**Application for a non-material amendment following a grant of planning permission.
Town and Country Planning Act 1990**

Land to north of Whalley Road, Hurst Green between Warren Fold and School Lane, comprising field and part field and school car park.

Erection of thirty dwelling houses, creation of a new access onto Whalley Road, new estate road, landscape, servicing, a replacement school car park, pick-up and drop-off provision, and public open space, along with demolition of the existing agricultural building.

# Plot 19 (House Type 968) - Foundation Plan & Ground Floor Plan

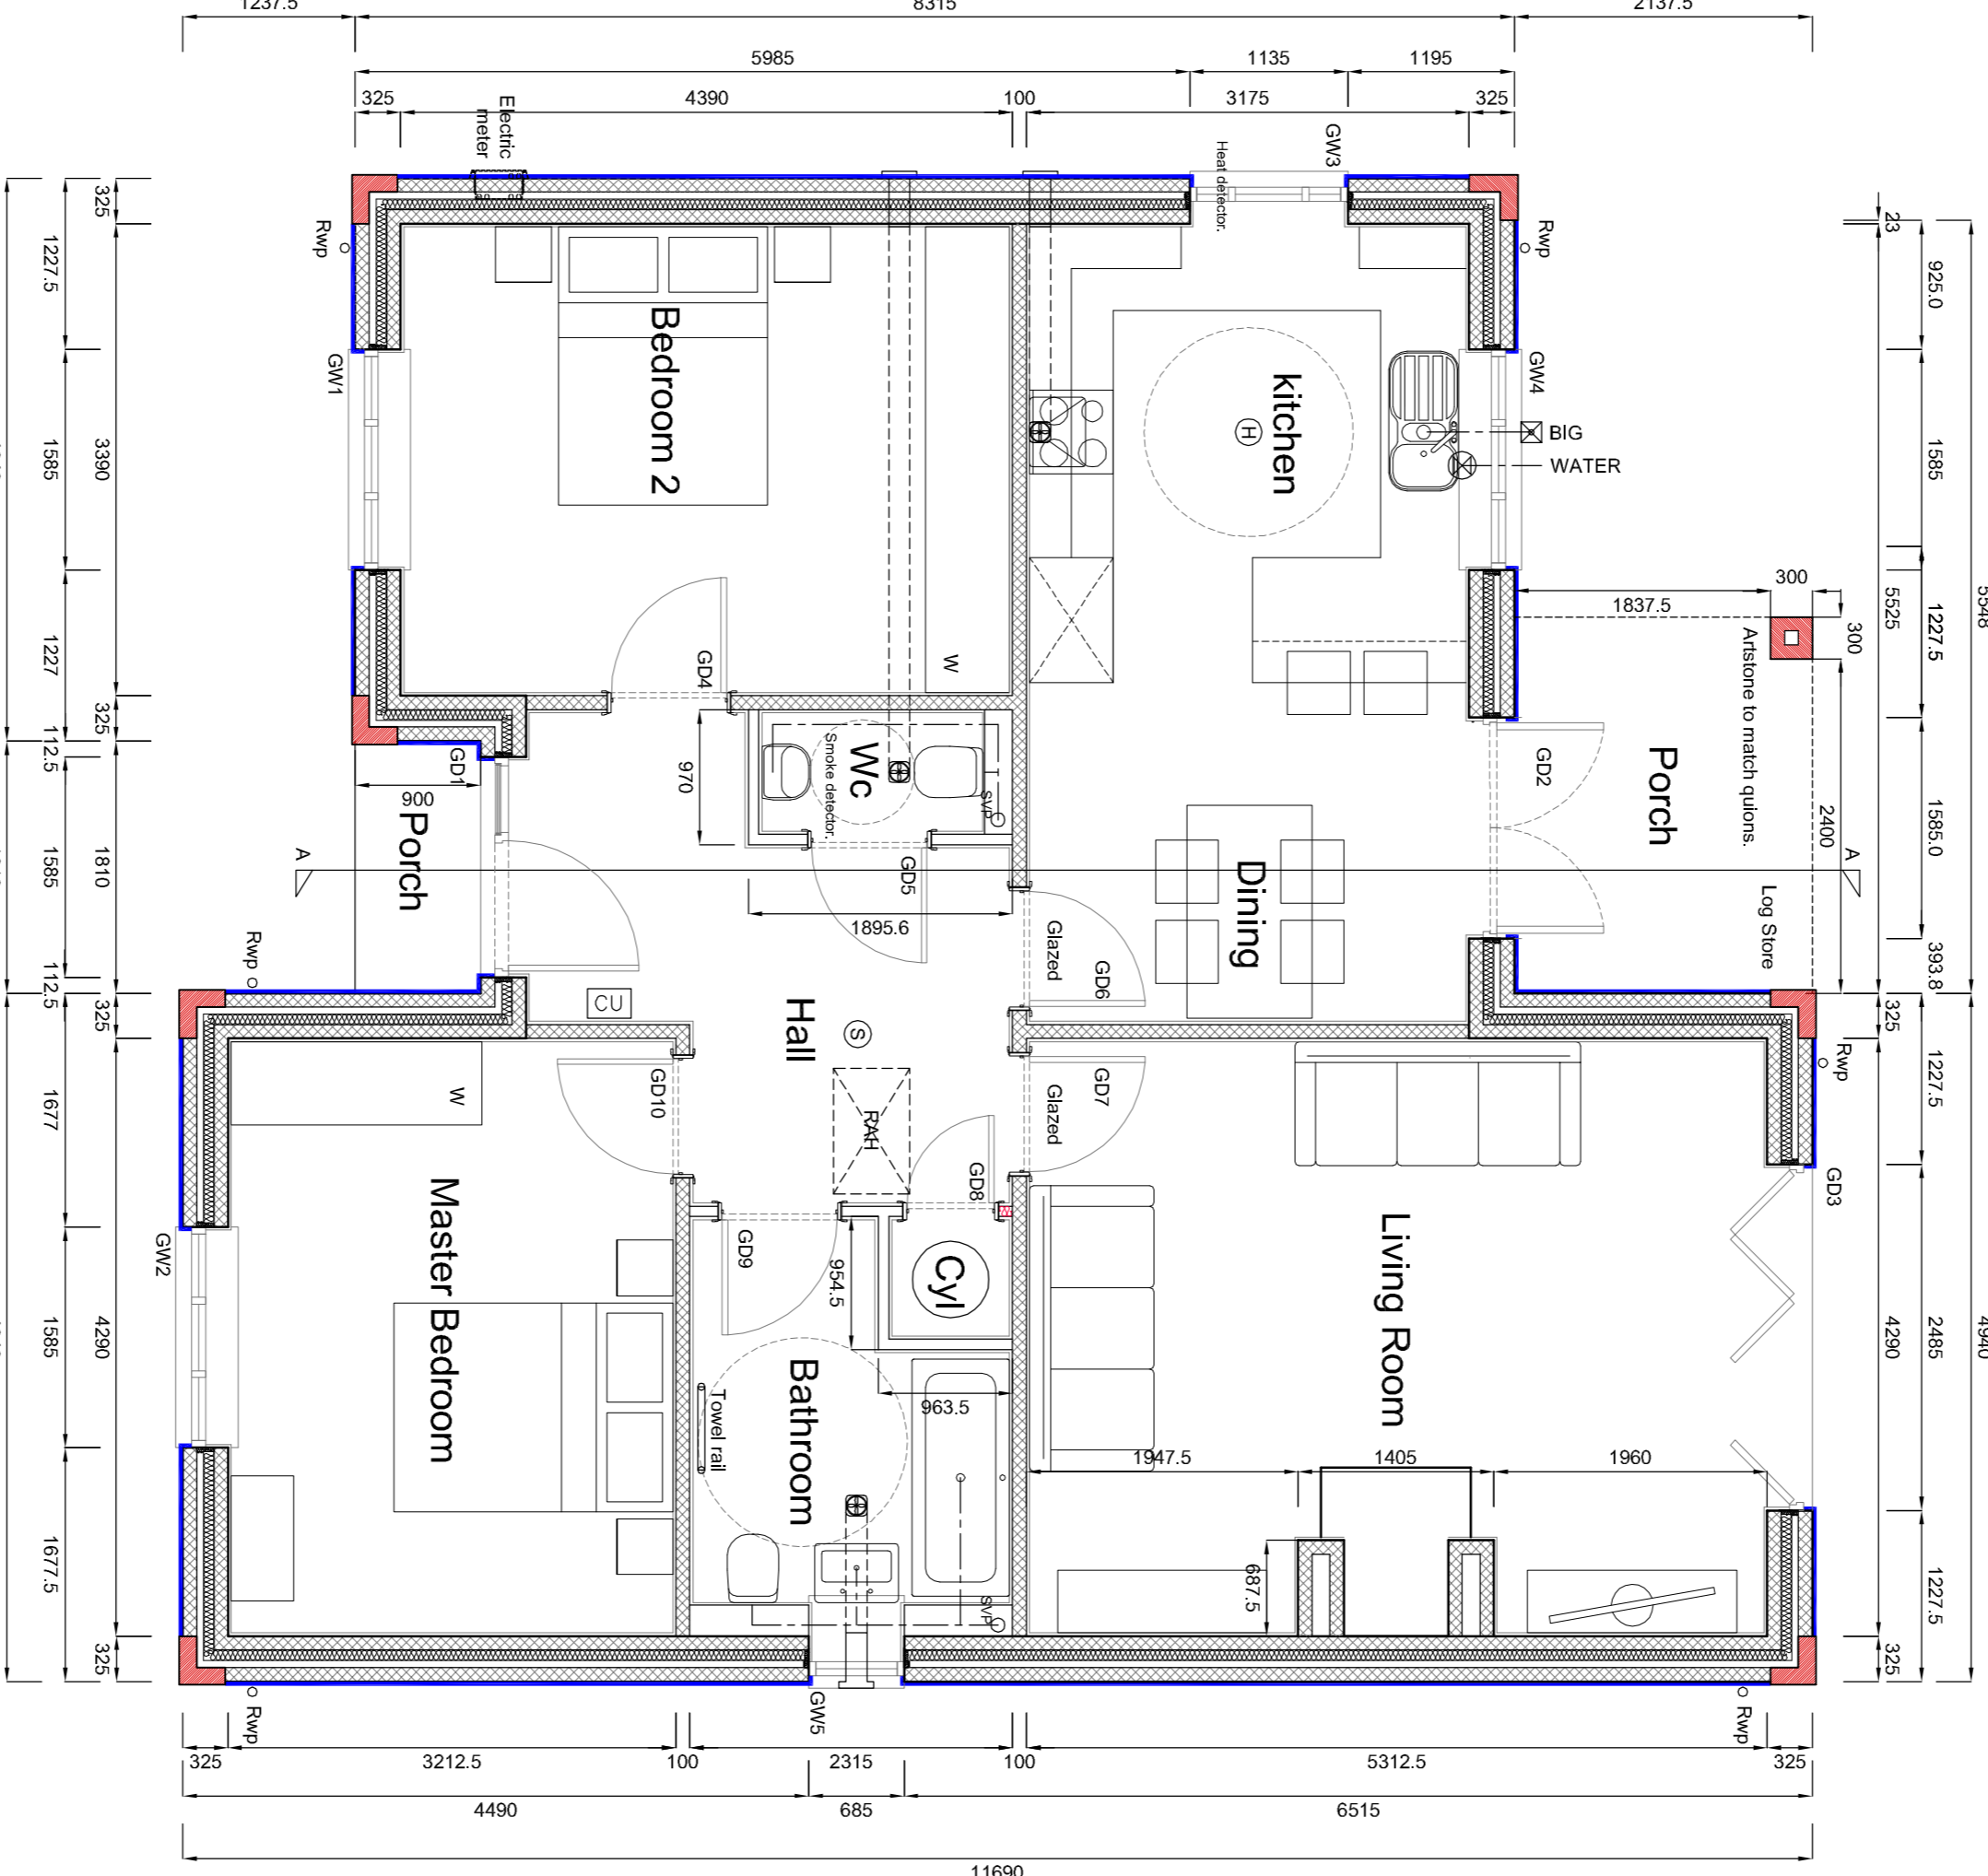
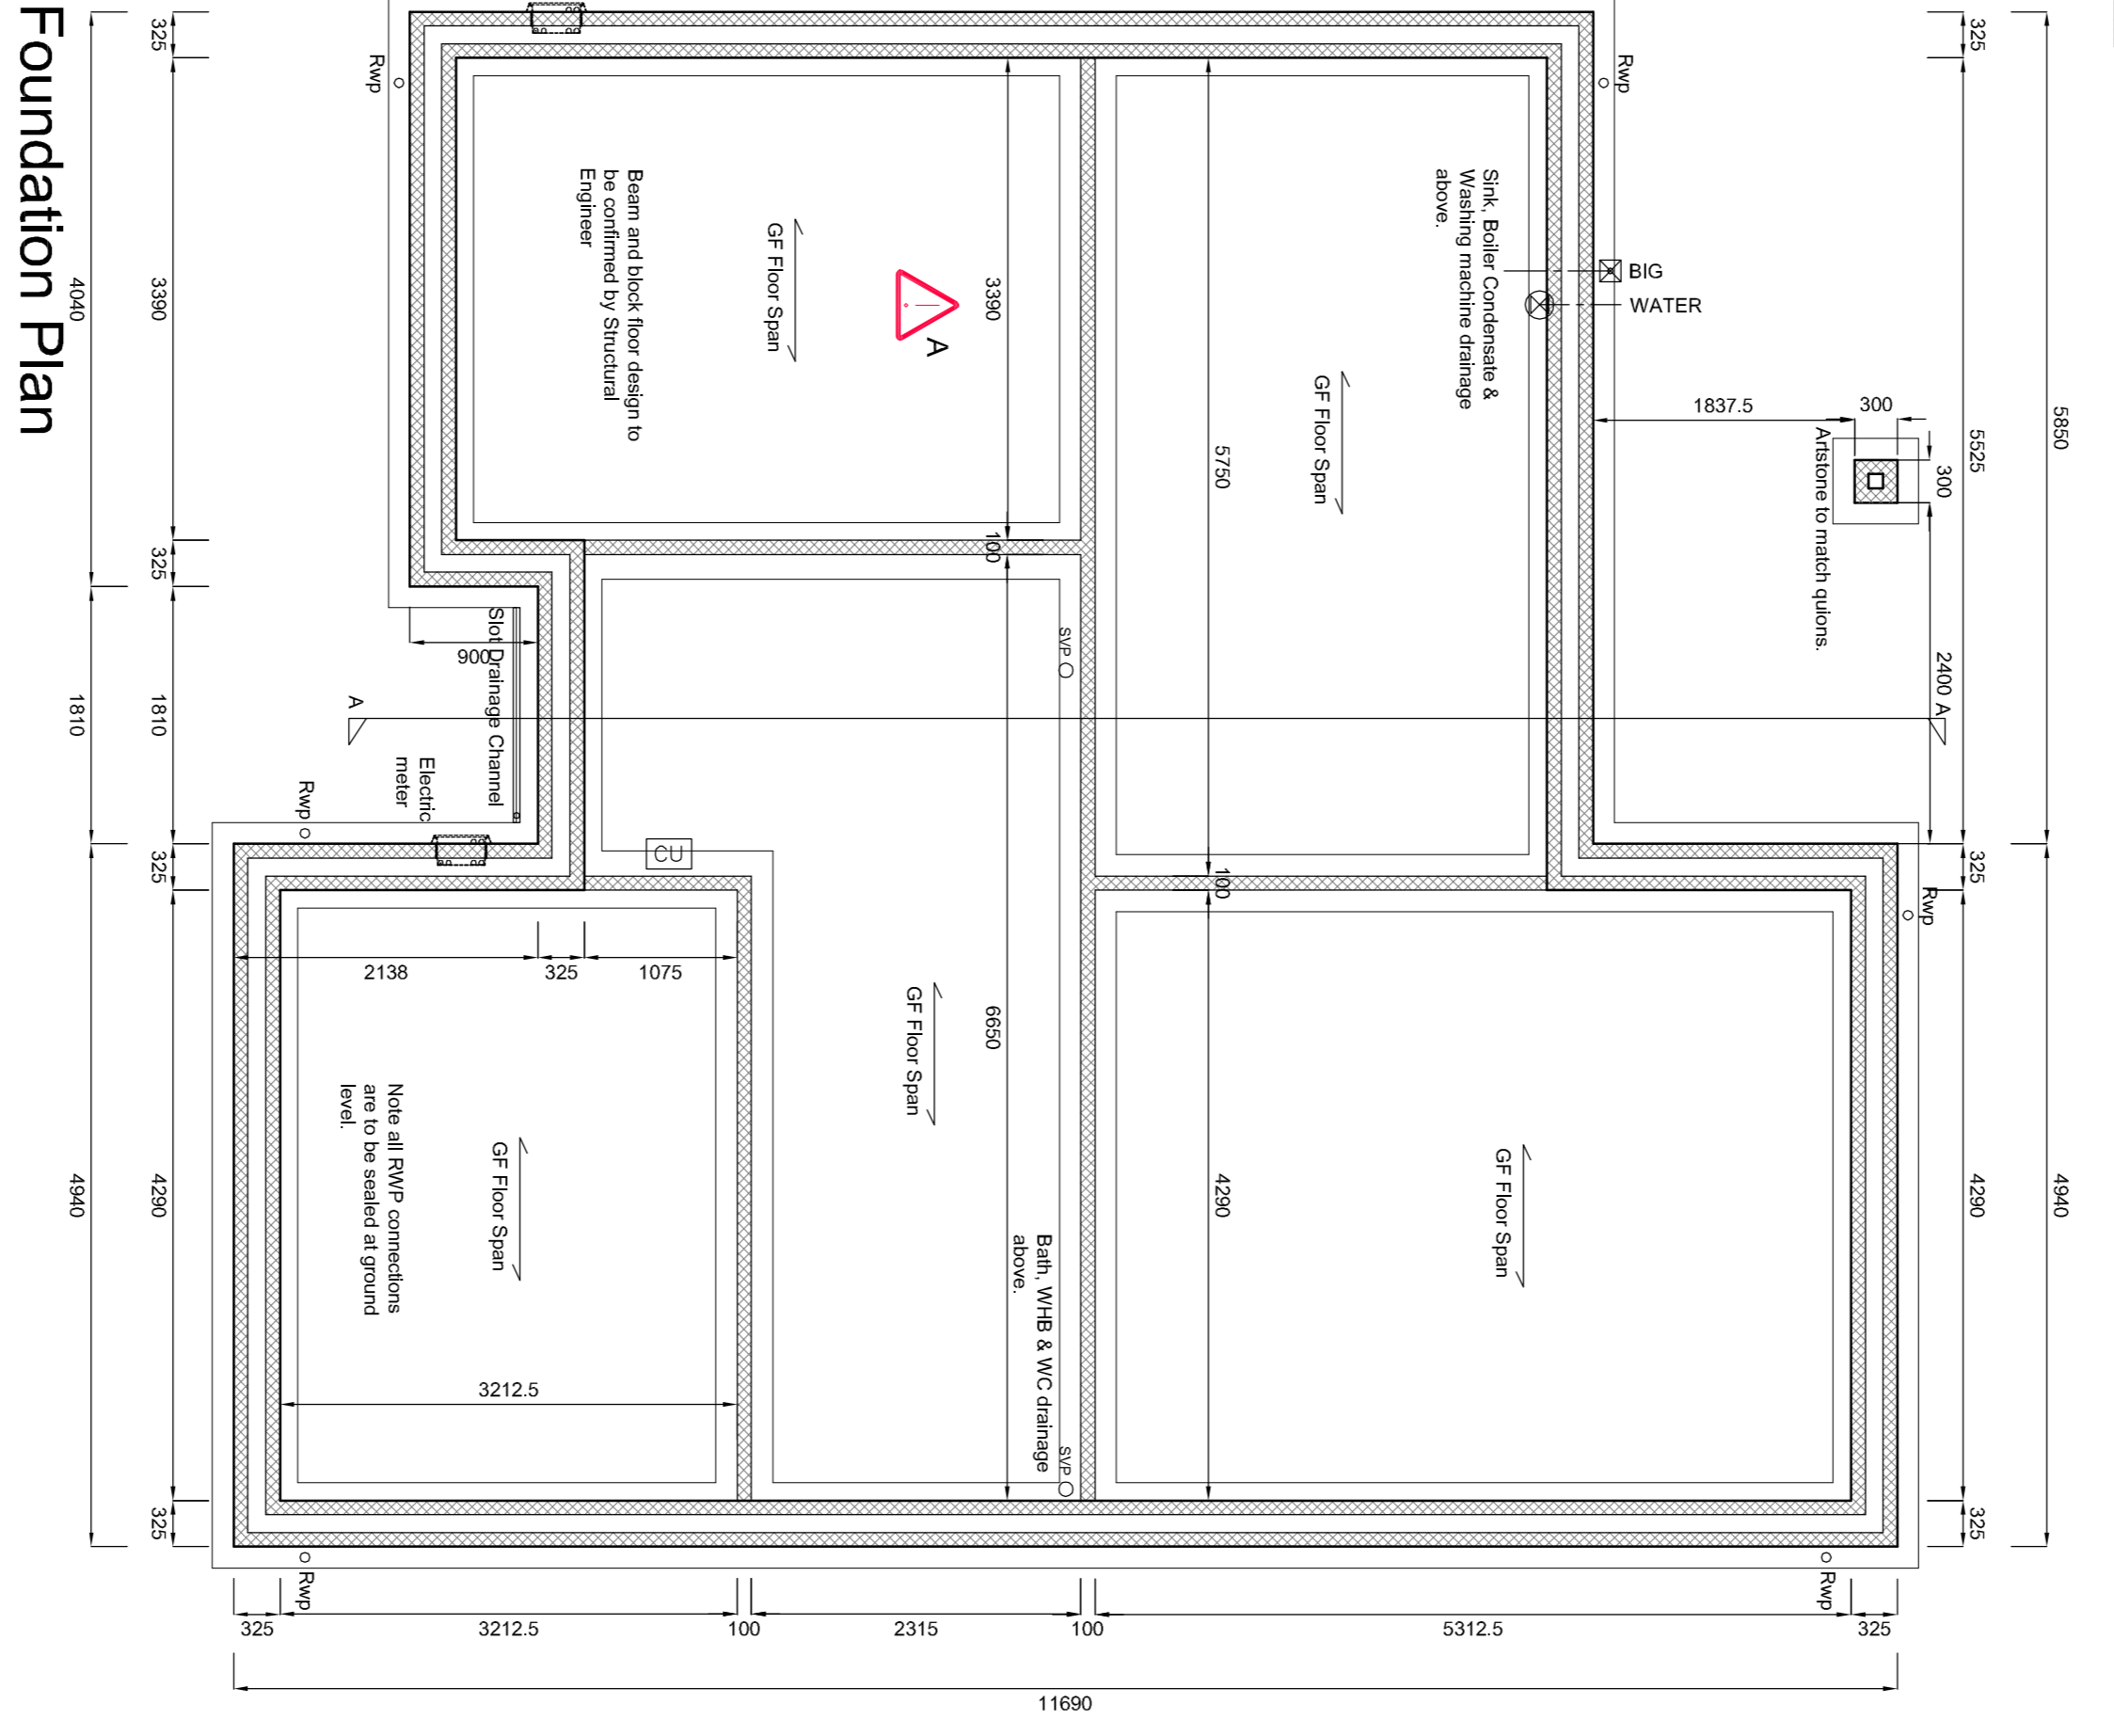
Update of approved materials on detailed elevations of all plots and garages
Revision to house types on plots 18 and 19
Revision to window details to form patio doors on plot 1
Removal of stone piers to driveways with corresponding removal of gates/fencing
Alteration to line of footpath on 'The Green' to avoid tree root protection zone
Revision to private road 5 and private drive to plots 23, 24, 25
